September 8, 2025

RE: Fahlgren Short Plat Final (SPF-25-00004) – Staff Review and Request for Final Mylars

SHEET 1 OF 2

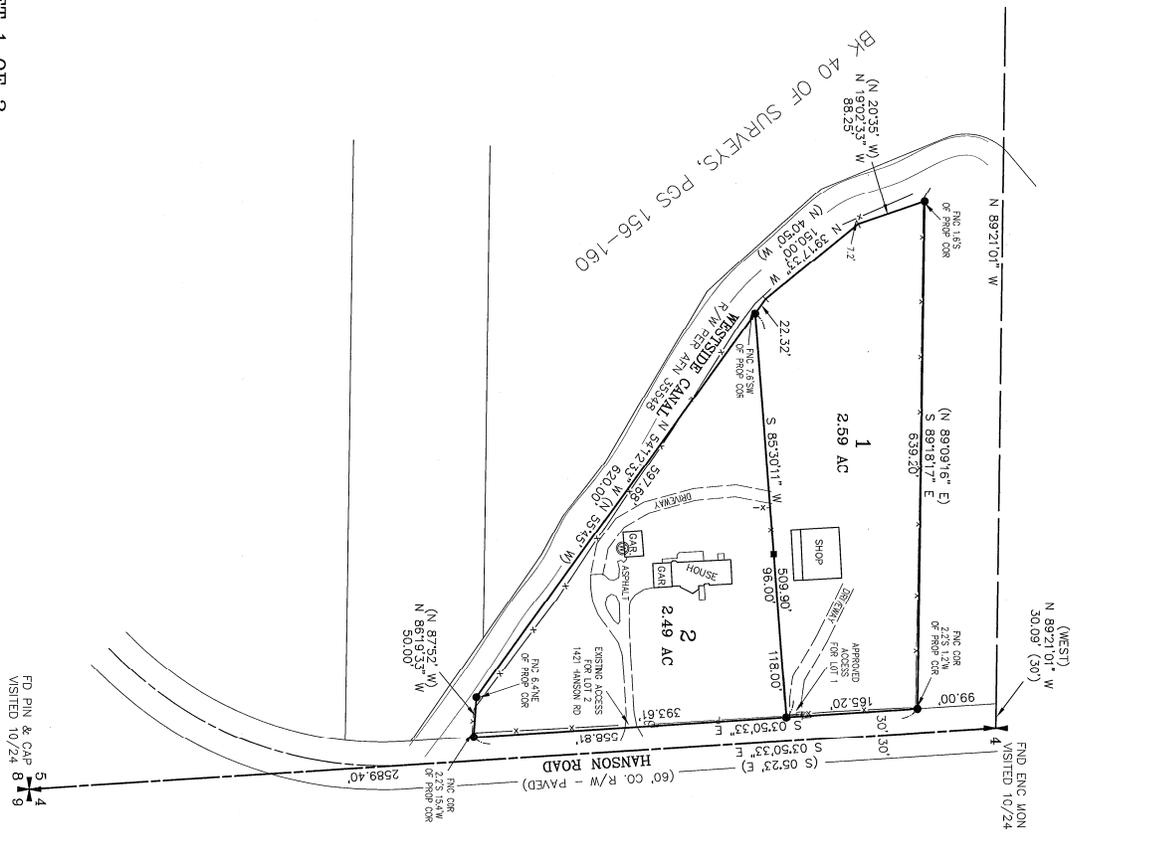
- Final mylars must include signature boxes for Kittitas Reclamation District and Westside Irrigation Company, and both signature boxes must be signed and dated respectively. CDS will not accept mylars that have not been signed by appropriate irrigation entities.
- “SPF-25-00004 Fahlgren” must appear on the face of each mylar sheet along with the Preliminary Short Plat project number “SP-24-00010 Fahlgren.”

- Please ensure the new parcels created in this Short Plat are identified with correct addresses upon final recording.
- Per County Surveyor: “Please include offset distances between the fence and the property deed line.”
- Per County Surveyor: “At a minimum property corners will need to be set and shown on the map for the new division line. Please identify if the drainfield easement is herein created, existing, or to be established via a separate document.”
